# Norfolk Vanguard Offshore Wind Farm Minor Change Request: Amendment to land rights sought at the existing National Grid Substation

Applicant: Norfolk Vanguard Limited  
Document Reference: ExA; ISH1; 10.D4.1  
Deadline 4

Date: March 2018

11. These proposed changes for sheets 40 and 41 of the Land Plans are shown on Figures 1, 2, 3 and 4 below:

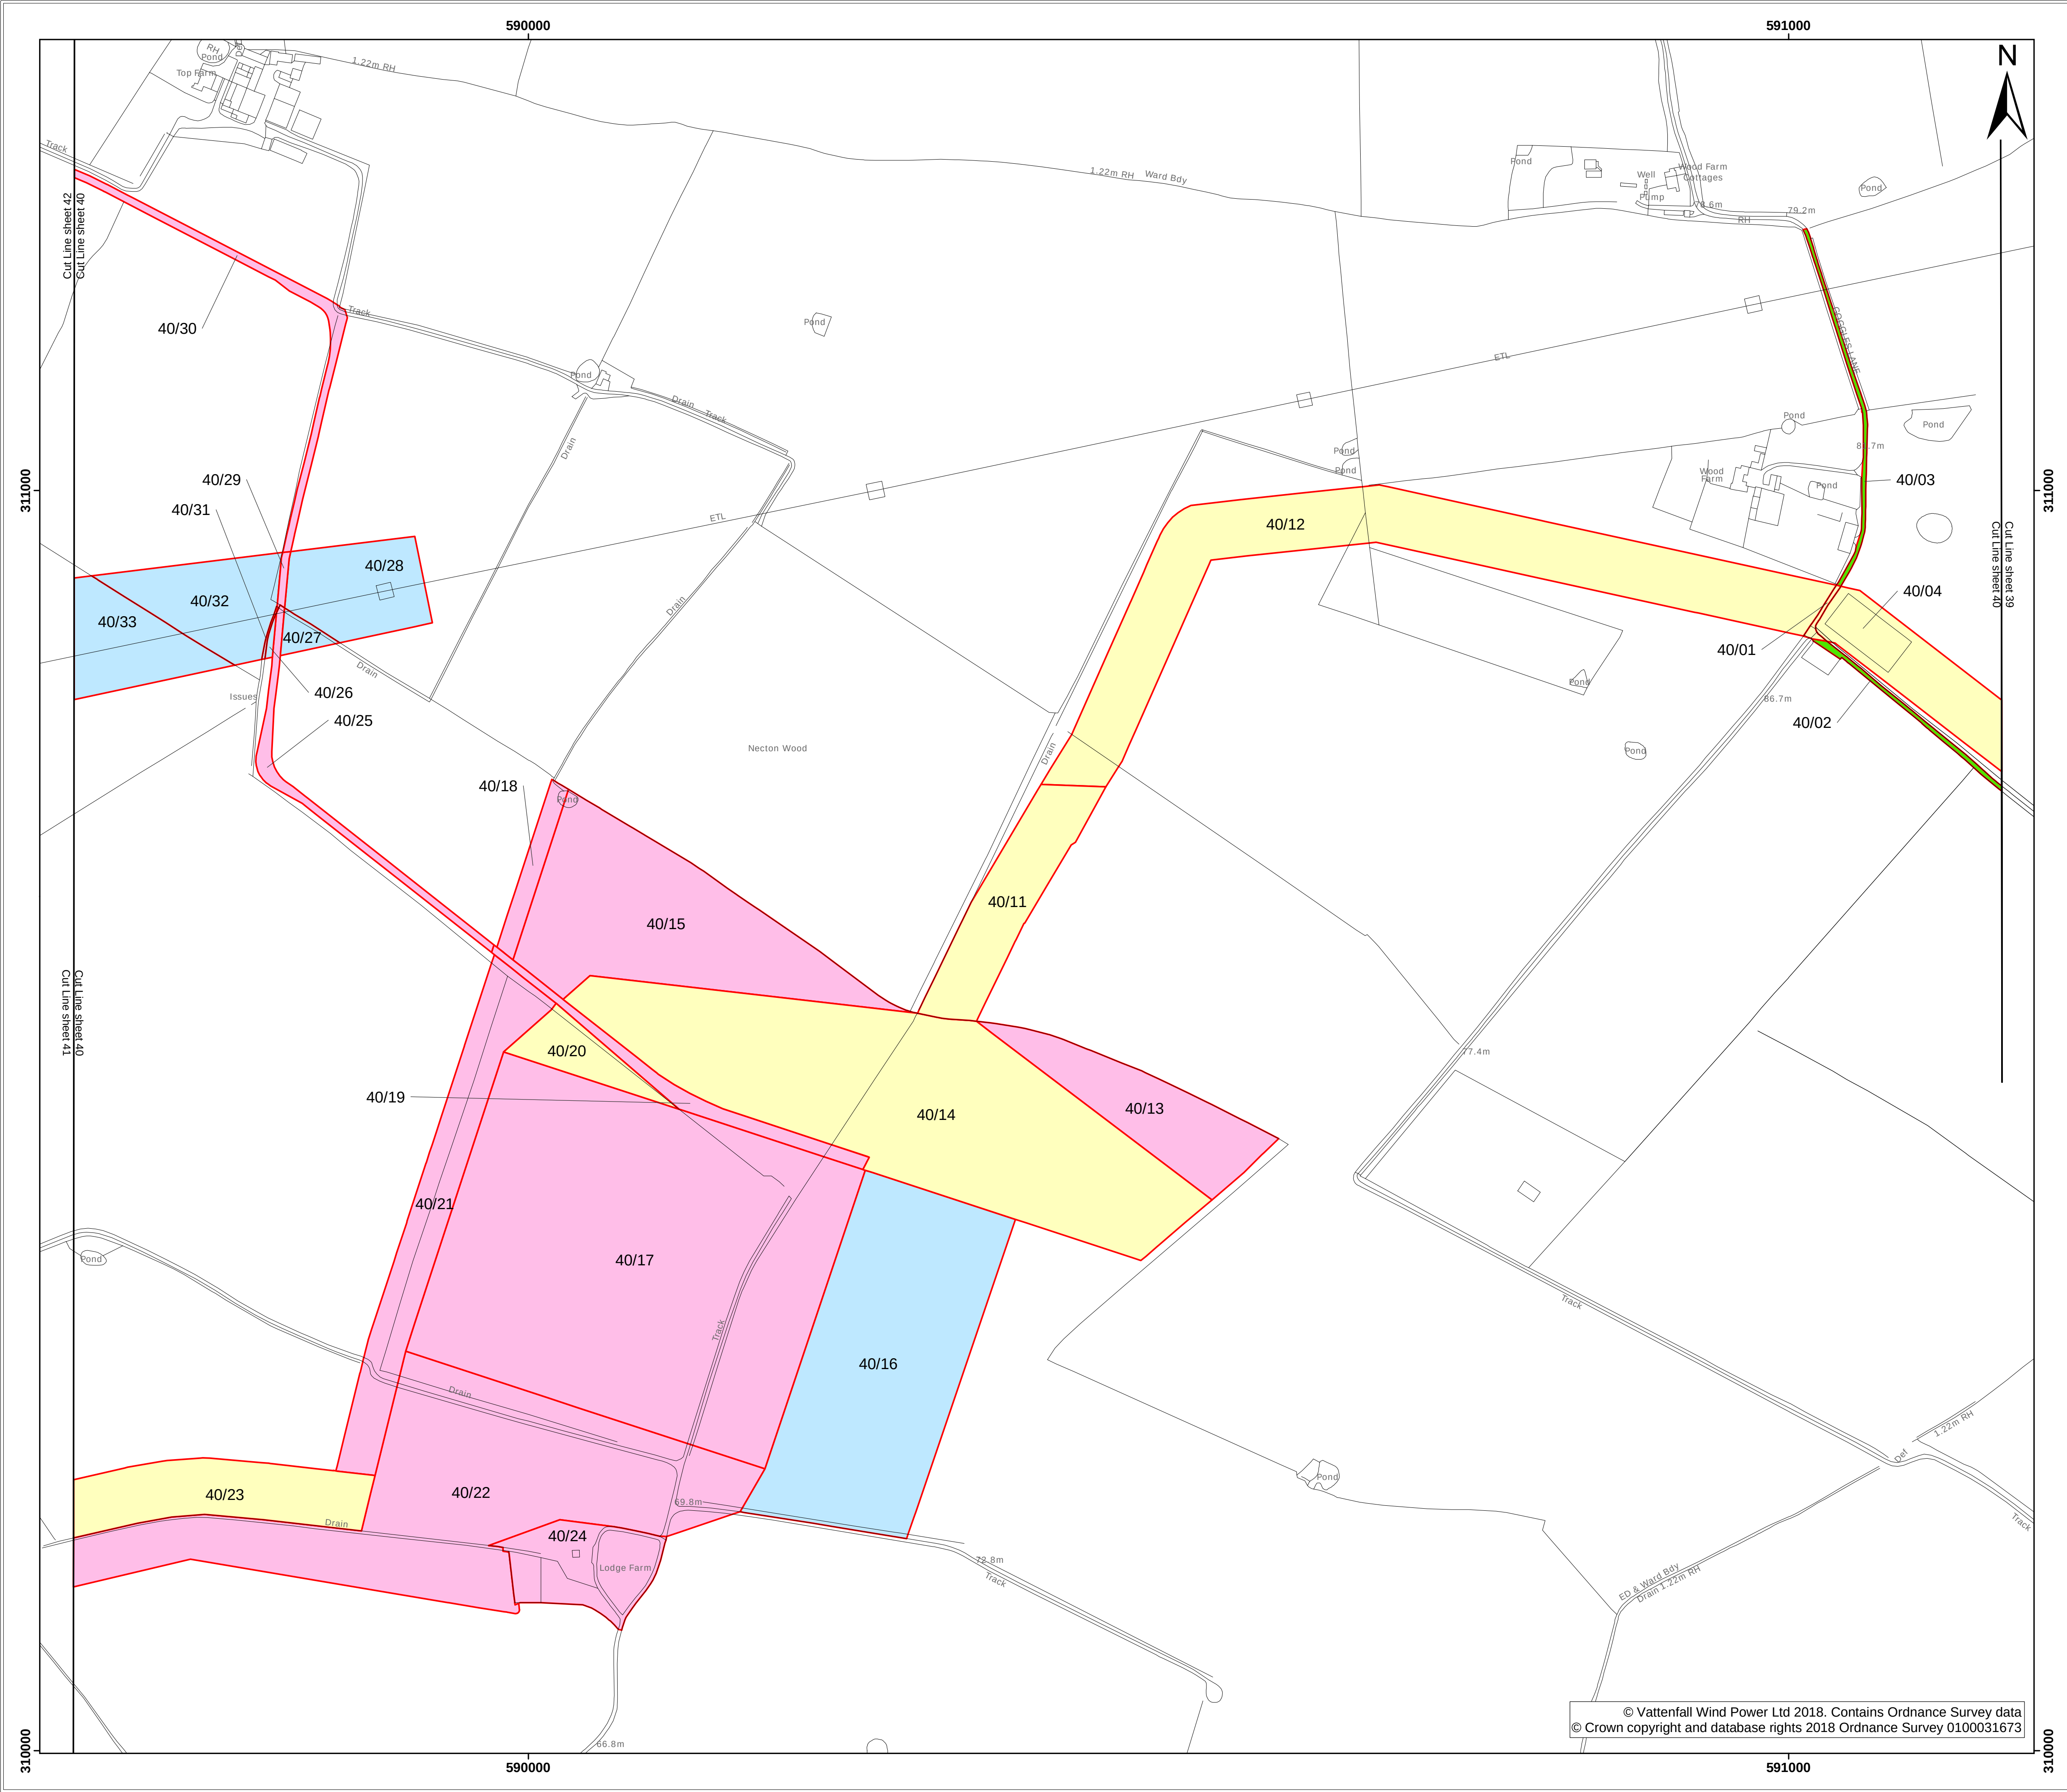
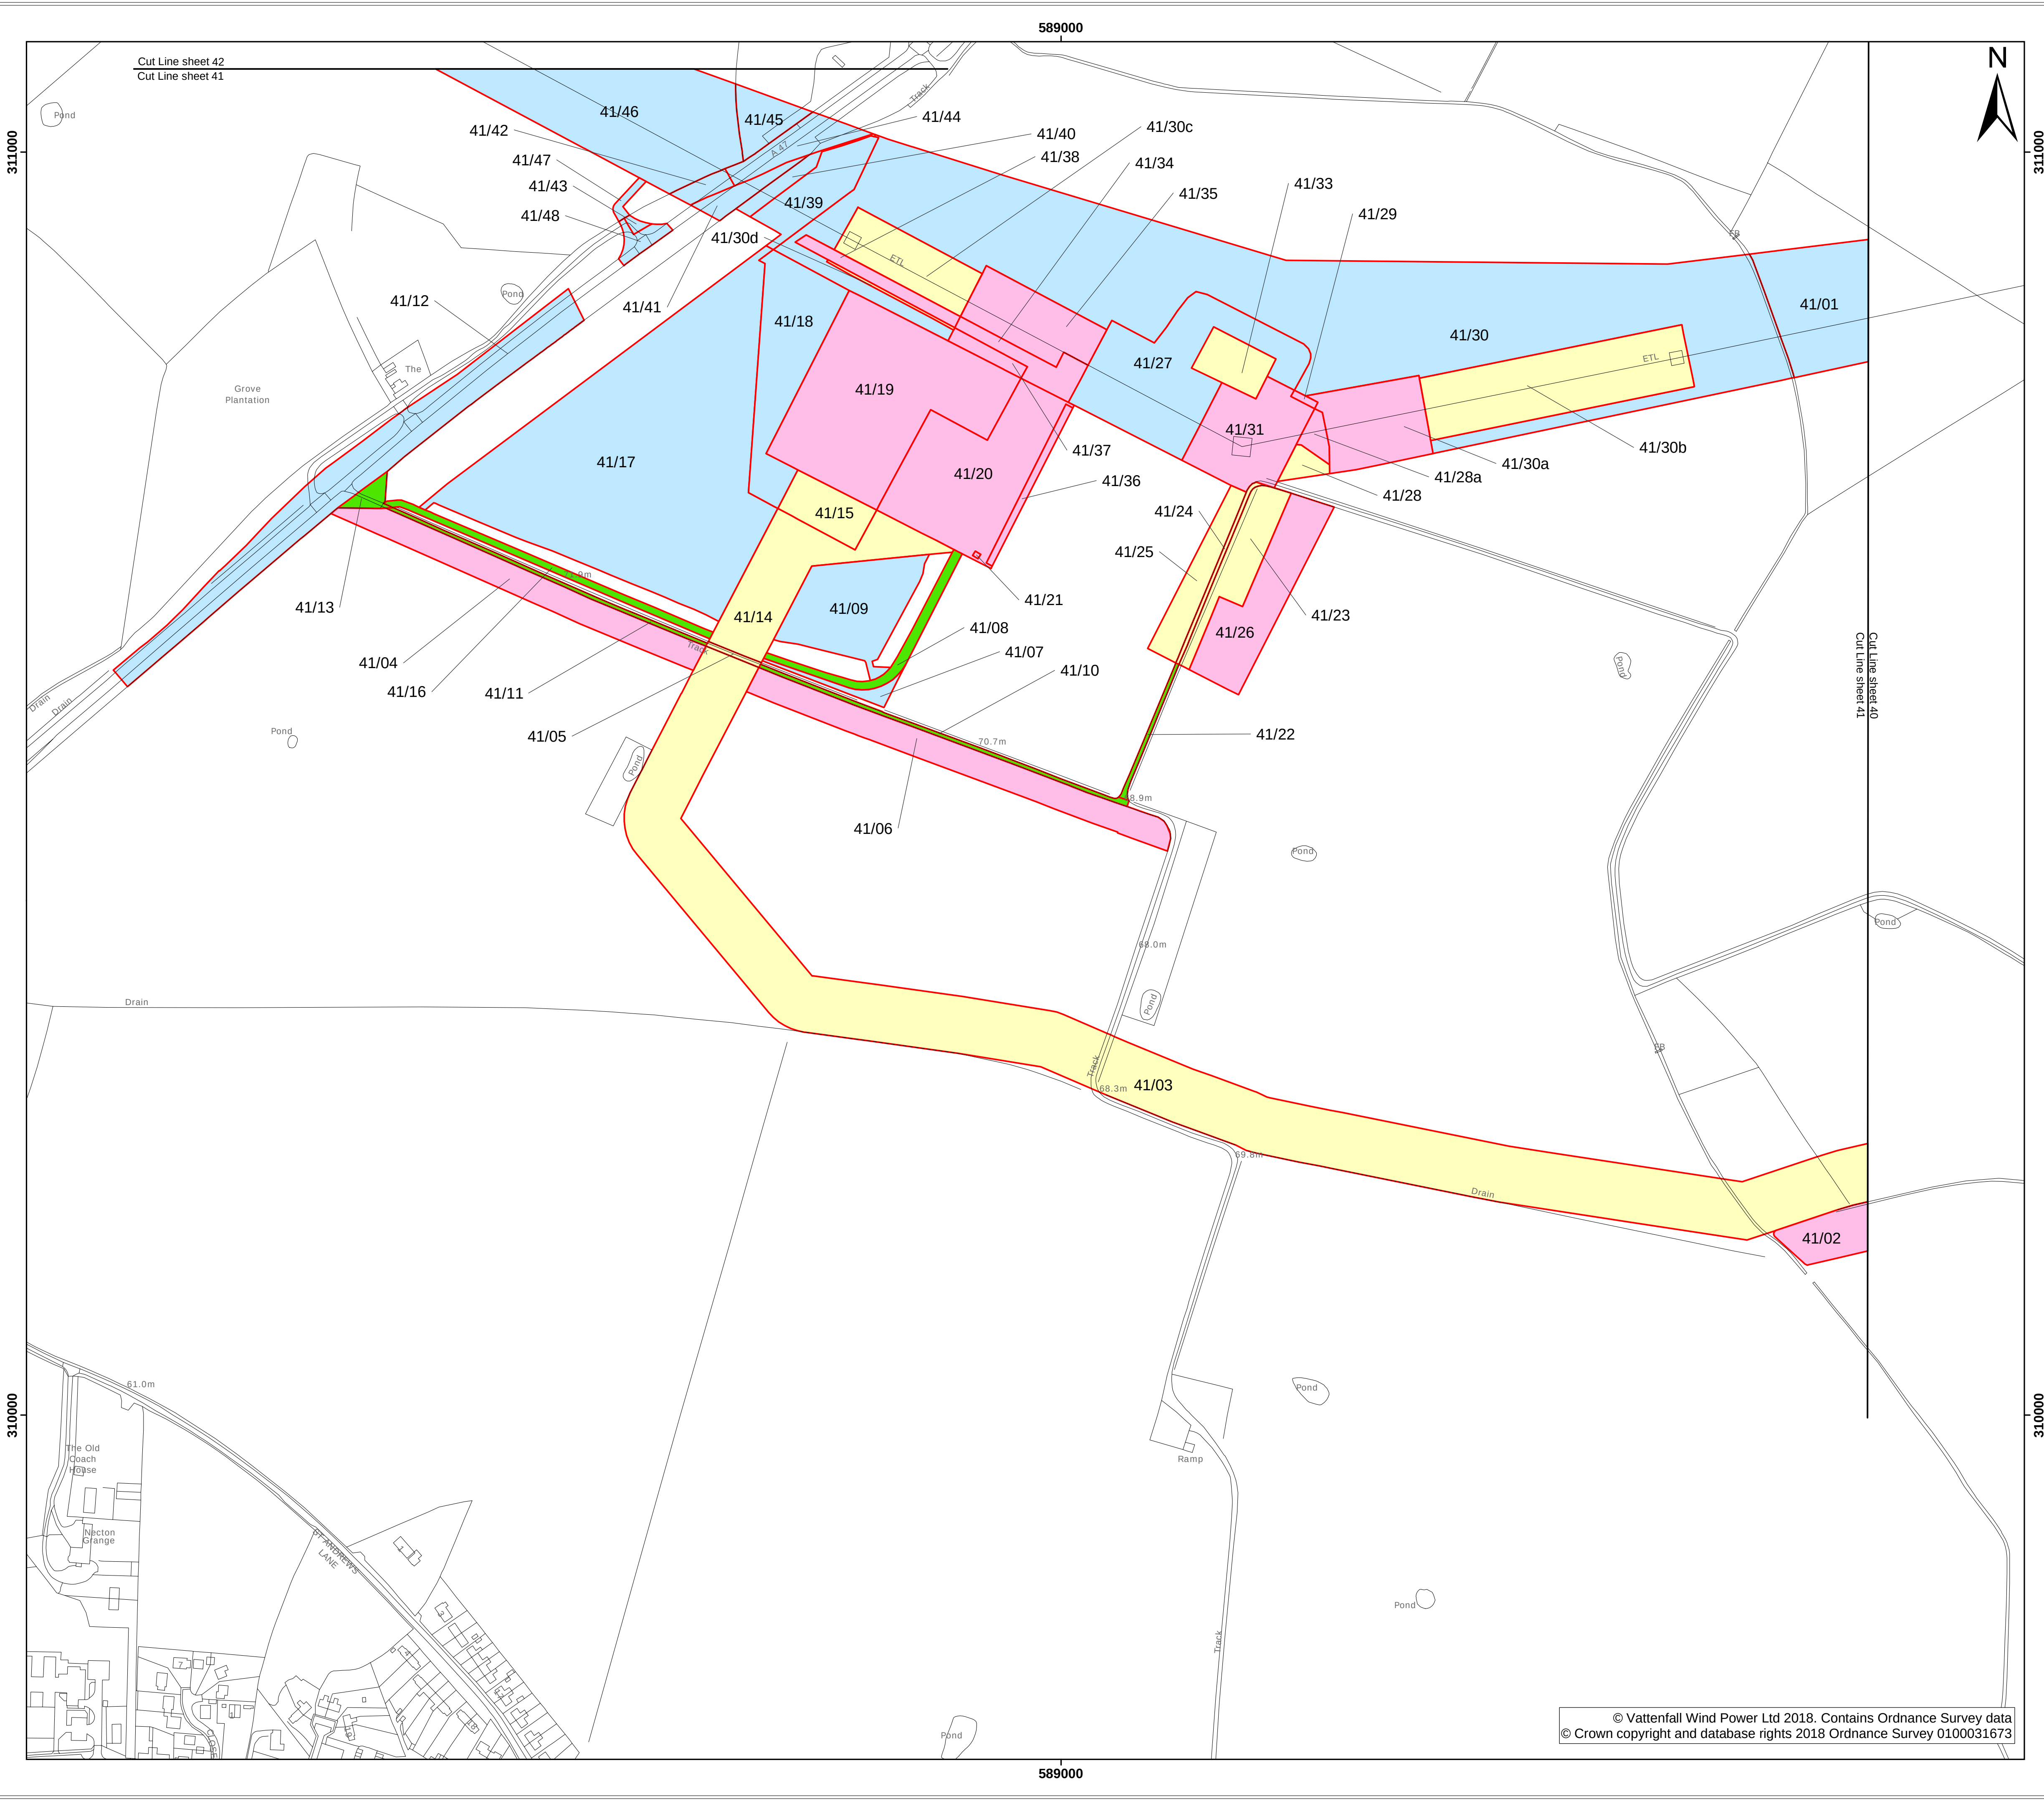
10. Since the Change Report was submitted, the Applicant has been in correspondence with National Grid in relation to National Grid's existing wayleave agreement with the affected landowner (the Wayleave). The overhead line works, as would be authorised by Work No.11A, are not permitted by the Wayleave and it is for this reason that permanent new rights are sought under the DCO. As the overhead line works are not permitted under the Wayleave, the works will also have the effect of rendering the entire Wayleave unenforceable. The existing Wayleave extends beyond the area of the overhead line works, further across the affected landowner's landholding. To remedy this it is necessary to ensure that permanent rights for the overhead line within the affected landowner's landholding are secured in the DCO. This will replace those rights which will be lost under the Wayleave and enable this part of the overhead line to remain in situ.

12. The Applicant has submitted revised drafts of the Land Plans at Deadline 4 (document reference 2.2 (version 3)) to capture these changes (as shown above). The Applicant has consulted with the affected landowner in order to seek consent for the proposed change. The landowner is the same landowner that the Applicant previously engaged with in order to obtain consent for the relevant changes under the Change Report.
13. The Applicant has obtained the landowner's consent to this change and to the inclusion of compulsory acquisition powers accordingly; the consent letter is included at Appendix 1.
